REQUEST	Current Zoning: B-1, neighborhood business Proposed Zoning: NS, neighborhood services
LOCATION	Approximately .30 acres located on the south side of East 36 th Street between North Davidson Street and the Norfolk Southern Railroad.
CENTER, CORRIDOR OR WEDGE	Corridor
SUMMARY OF PETITION	This petition proposes to rezone the property to allow a freestanding wooden deck located in the rear of the property to be used by the adjacent tenant. Both properties are under the same ownership.
STAFF RECOMMENDATION	Staff recommends approval of this petition, upon resolution of outstanding issues. The petition is consistent with the <i>North Charlotte Plan</i> land use recommendation for neighborhood commercial land uses, and consistent with the <i>Northeast LRT Transit Station Area Concept</i> land use recommendation for retail uses.
Property Owner	Michelle Norkett Strause
Petitioner	Michelle Norkett Strause

PLANNING STAFF REVIEW

FOR PUBLIC HEARING PETITION #: 2008-057
 REZONING SURVEY OF:
DEBORAH MICHELLE NORKETT
 LOTS 3 & 4, BLOCK 1,
 MAP BOOK 230, PAGE 14
 446 EAST 36TH STREET
 CITY OF CHARLOTTE, MECKLENBURG COUNTY, N.C.
 DEED REFERENCE: 8460-388
 TAX PARCEL: 083-084-19

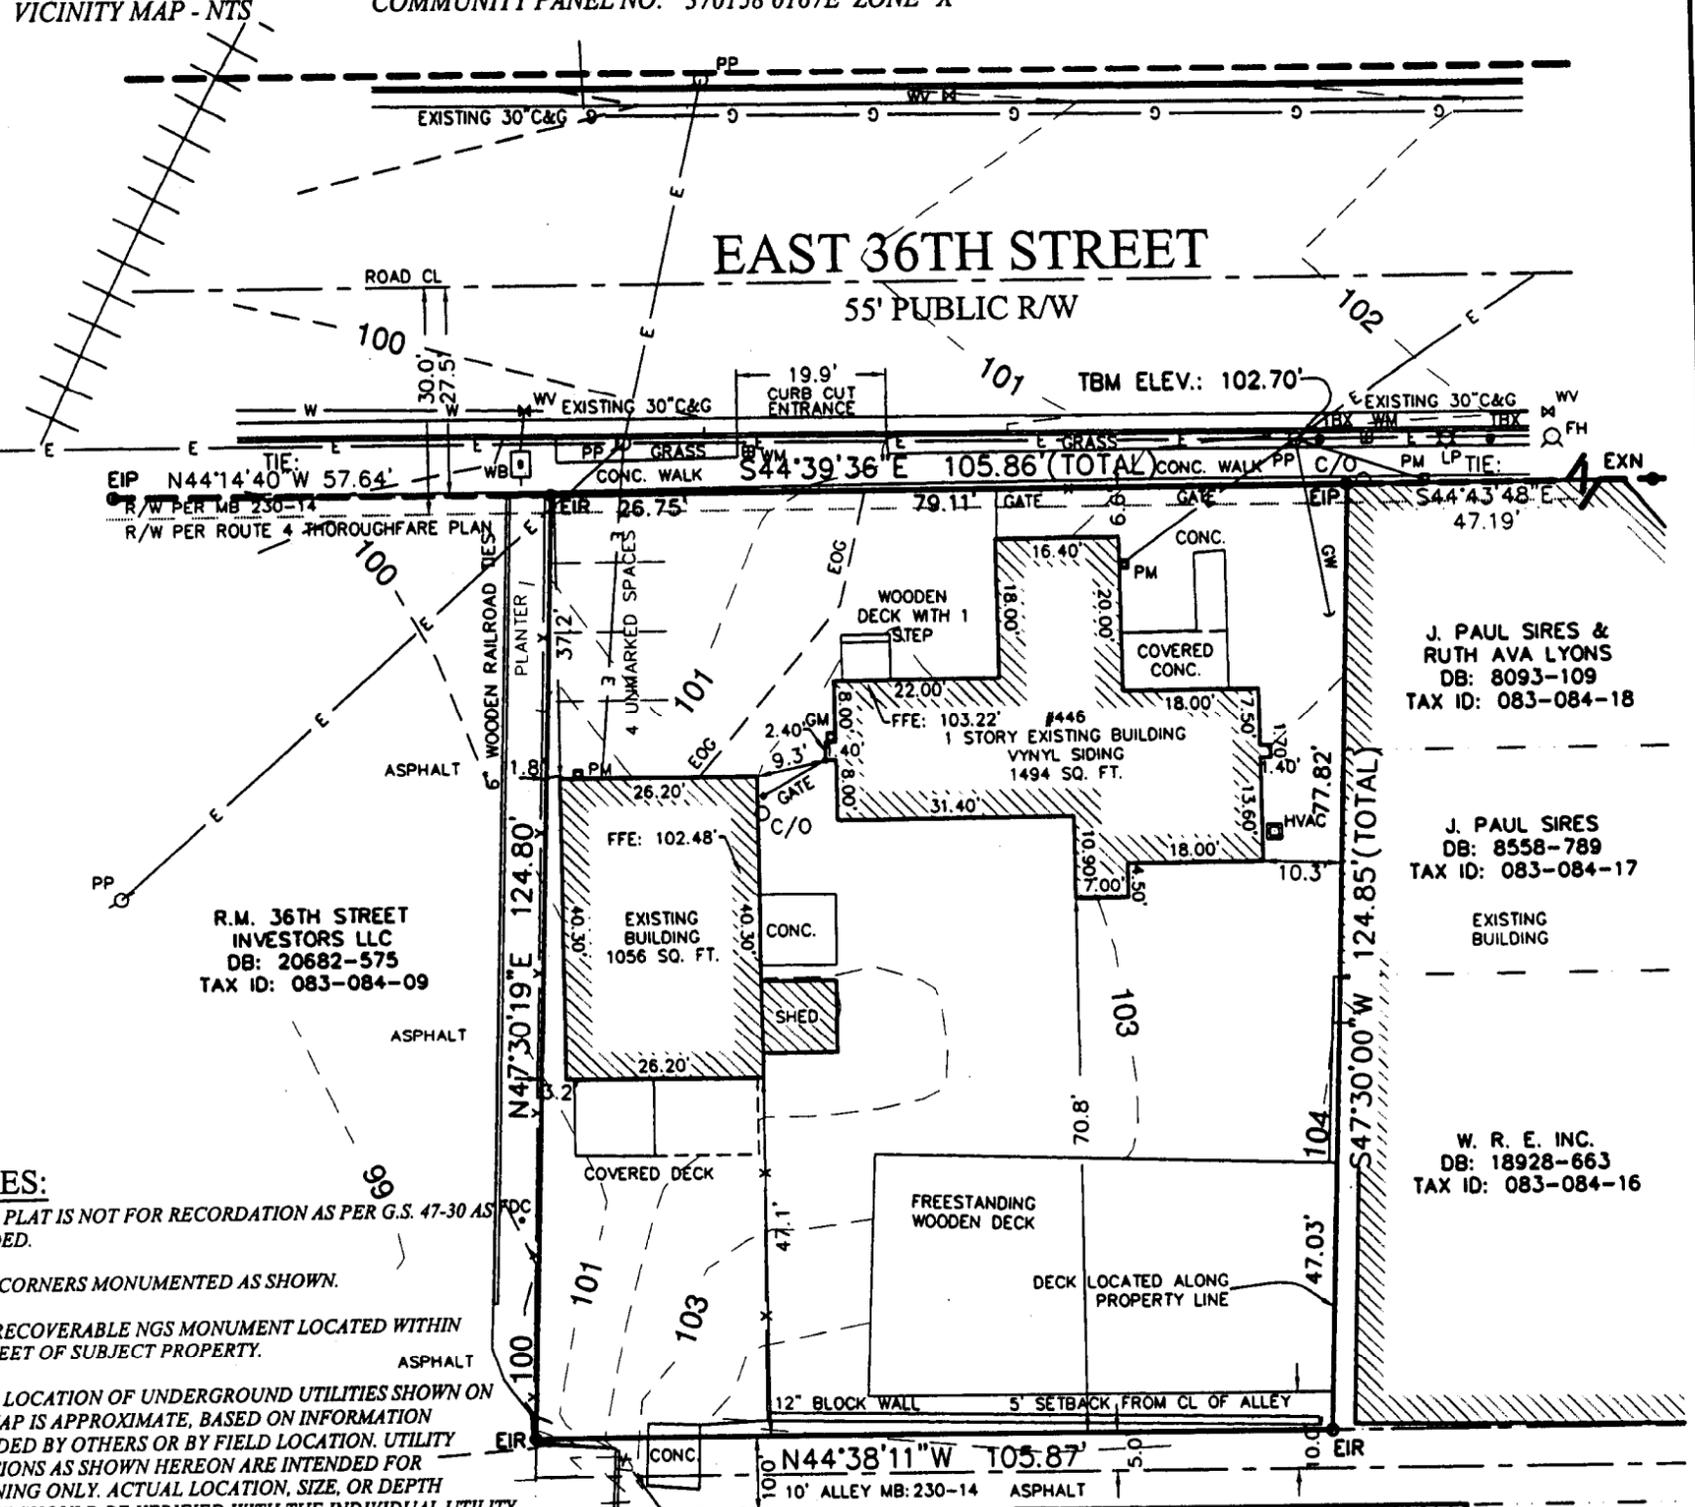
- The petitioner should:
 1. Add a note under "Zoning" that Restaurant parking will meet the minimum parking requirements of one space per 150 square feet, but no more than a maximum of one parking space per 75 square feet.
 2. Add a note that the maximum height of freestanding light poles will be 25'.
 3. Correct the text on the site plan that states, "5' setback from CL of alley" to read "10' rear yard from CL of alley".
-
